## Oakdale South SSD6917 MOD 4 – Response to Submissions

ELW - 001  
J  
21.06.2017

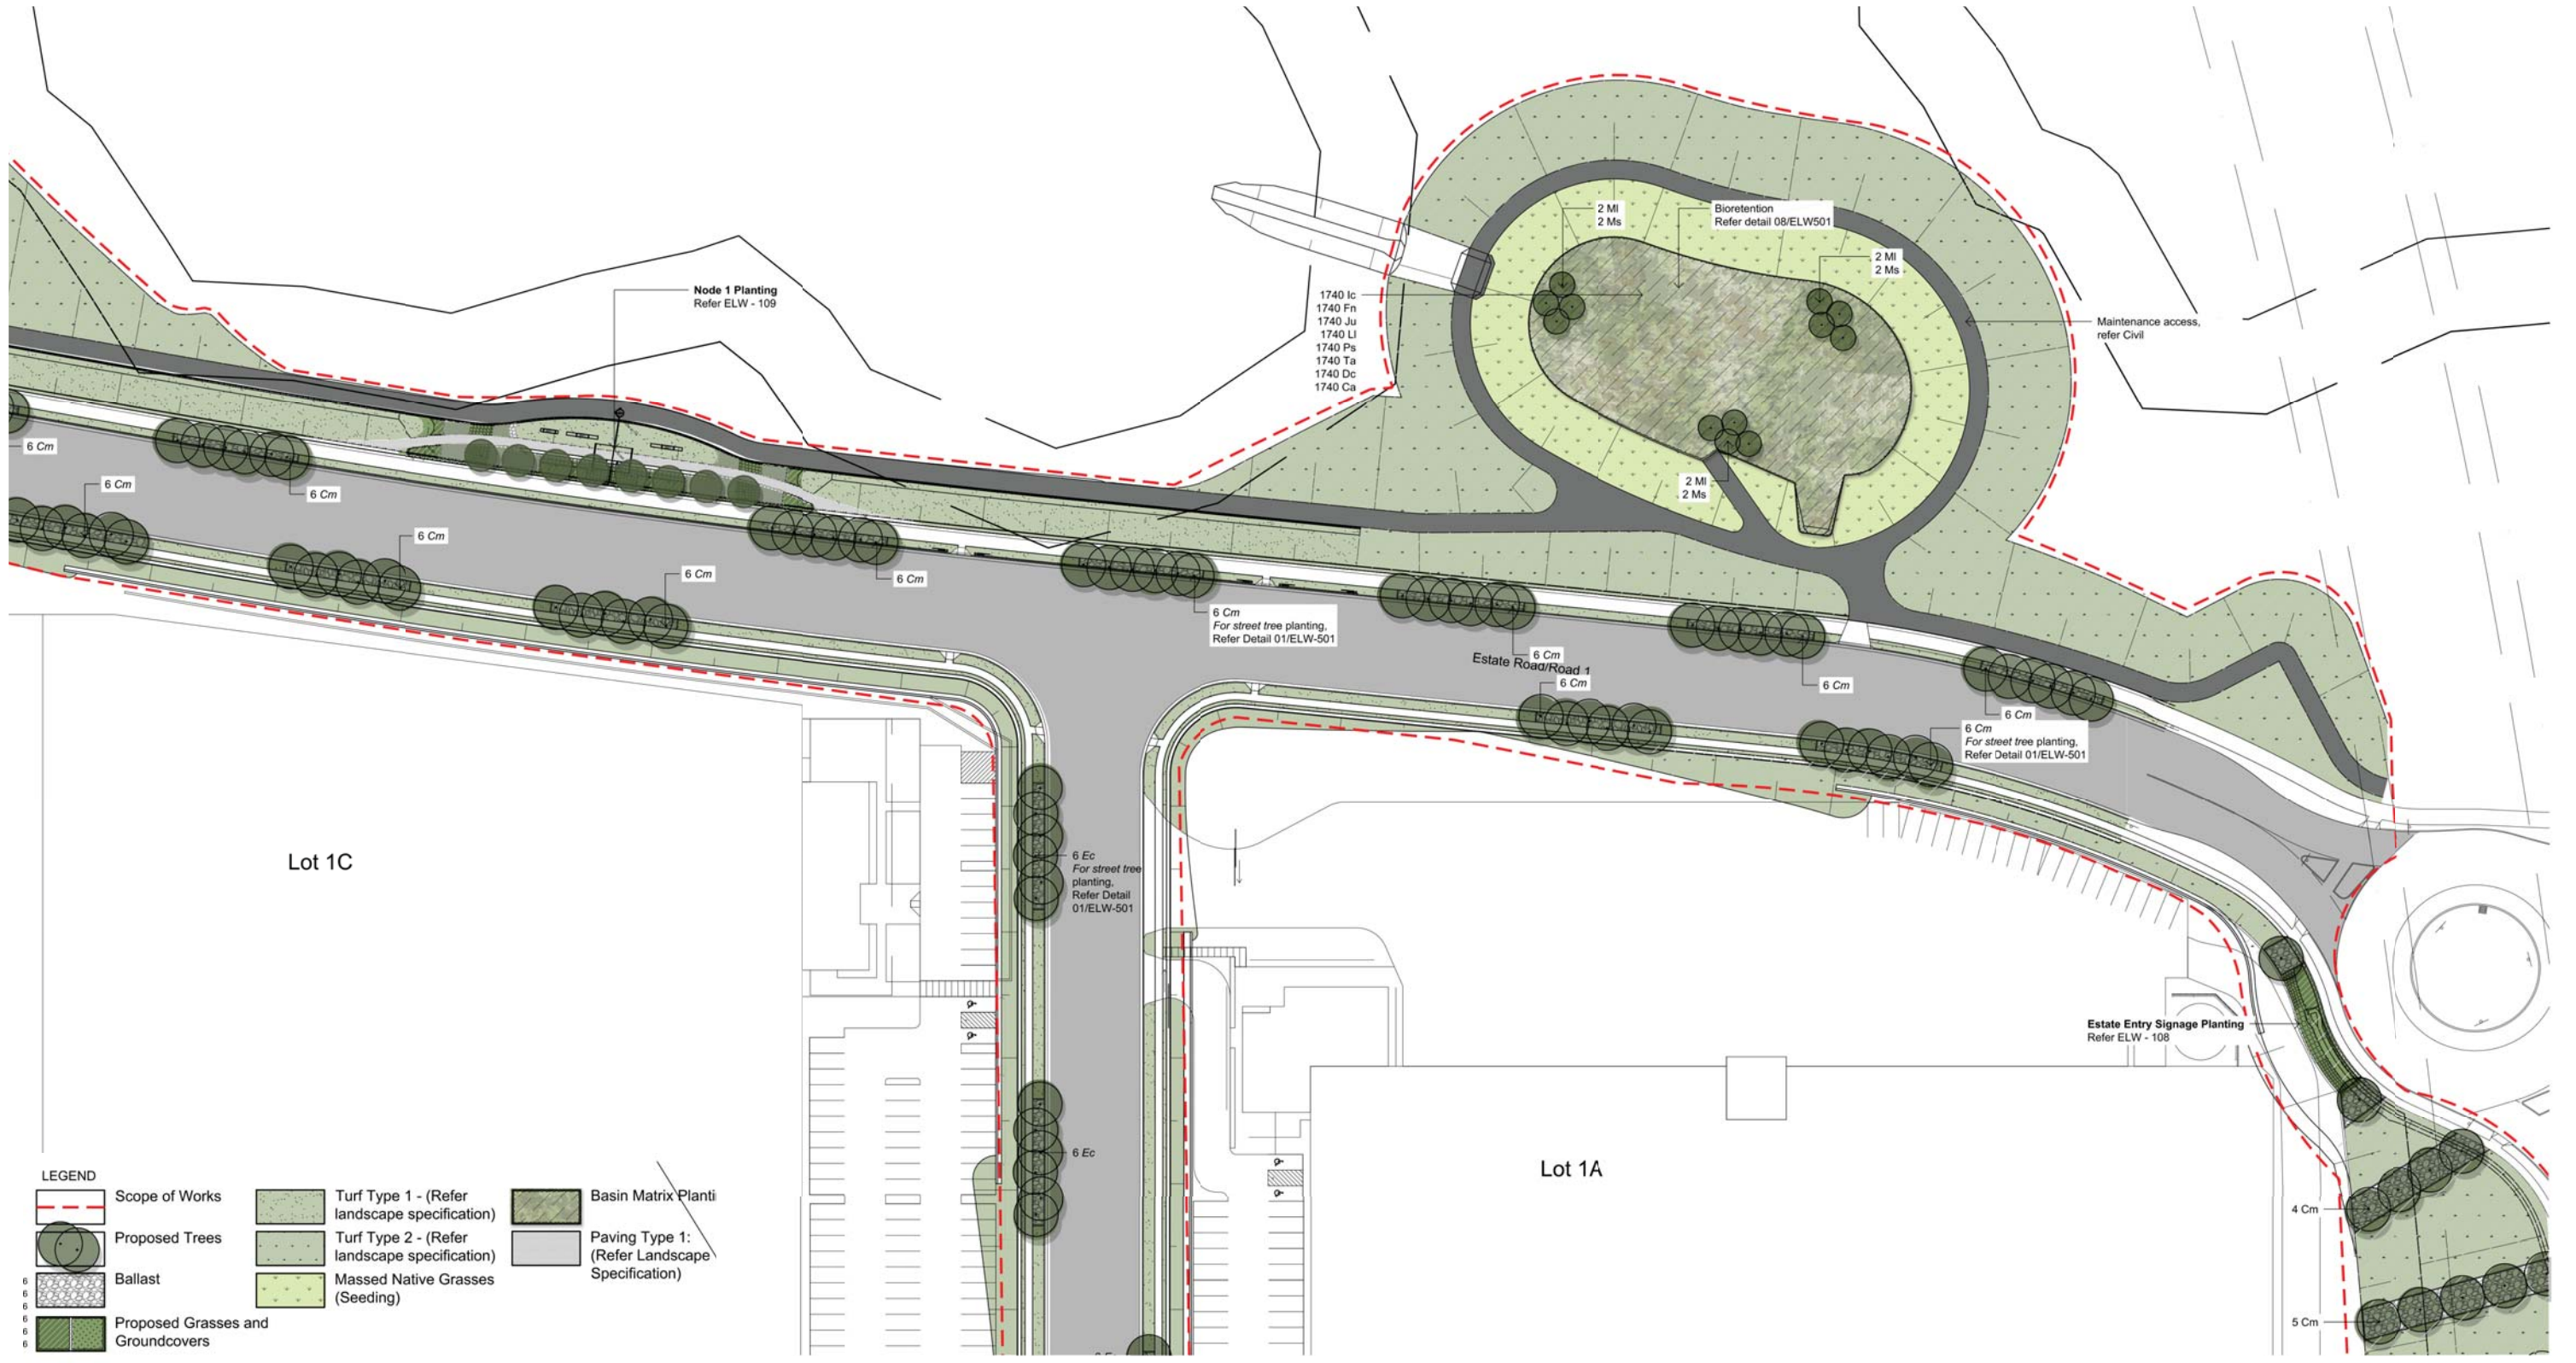
<p><u>Landscaping</u></p> <ul style="list-style-type: none"> <li>+ Please provide an amended Precinct Landscape Plan with a key or labels to clearly identify the planting to correspond with the tree schedule already provided.</li> </ul>	<ul style="list-style-type: none"> <li>+ The landscape plans for MOD4 are consistent in format and detail with the landscape plans submitted and approved by DoP for both the SSD6917 Concept and MOD1, providing an appropriate level of detail for DA stage drawings. More detailed landscape plans including specifications and maintenance guidelines are</li> </ul>

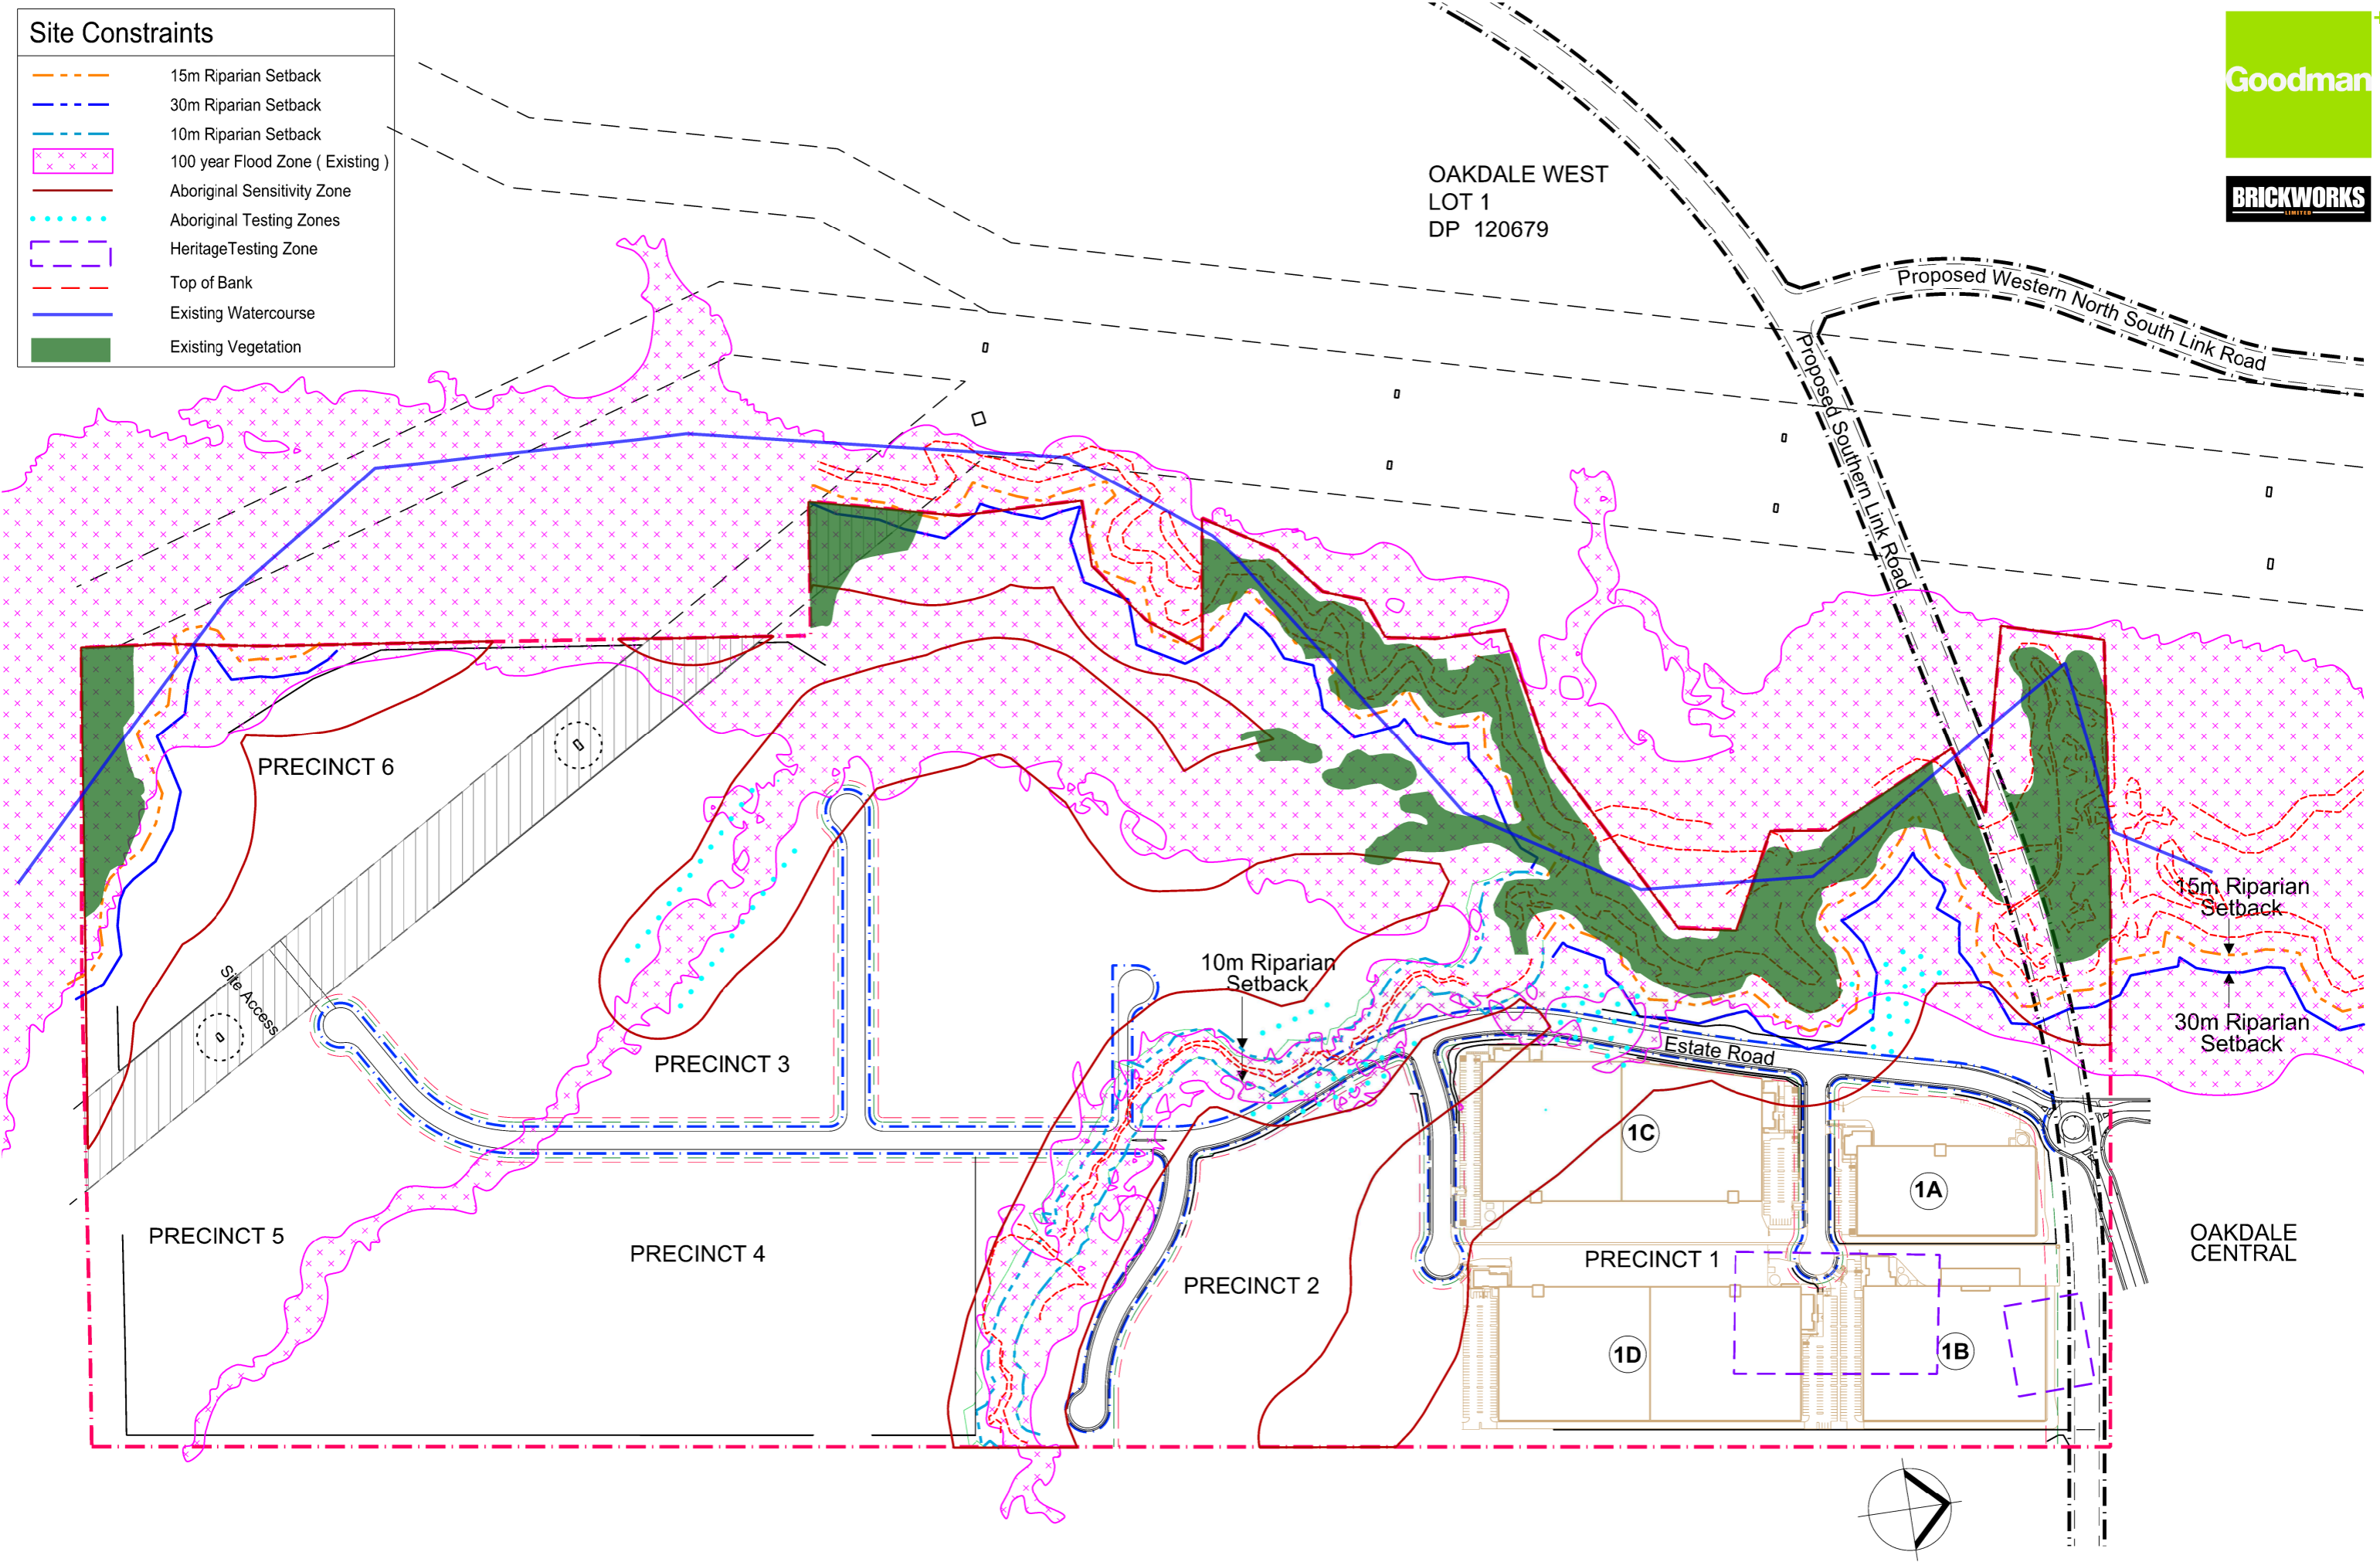
<b>RFS</b>	
<p><b>Asset Protection Zones</b></p> <p>1. A 26 metre asset protection zone (APZ) is to be provided along the eastern boundary of Biodiversity Lot 1 and the northern boundaries of Biodiversity Lot 2 and Lot 3 and a 10 metre APZ is to be provided along the southern boundary of Biodiversity Lot 2 as shown on the plan titled 'Bushfire Protection Plan' OAK MP 13 (N) prepared by SBA Architects dated 2 August 2017. APZs to be maintained in accordance in 'Planning for Bush Fire Protection 2006' and the NSW Rural Fire Service's document 'Standards for Asset Protection Zones'.</p>	<ul style="list-style-type: none"> <li>+ Noted. The Bushfire Protection Plan (MP13 (N) has been updated to incorporate all these suggested protection zones.</li> </ul>
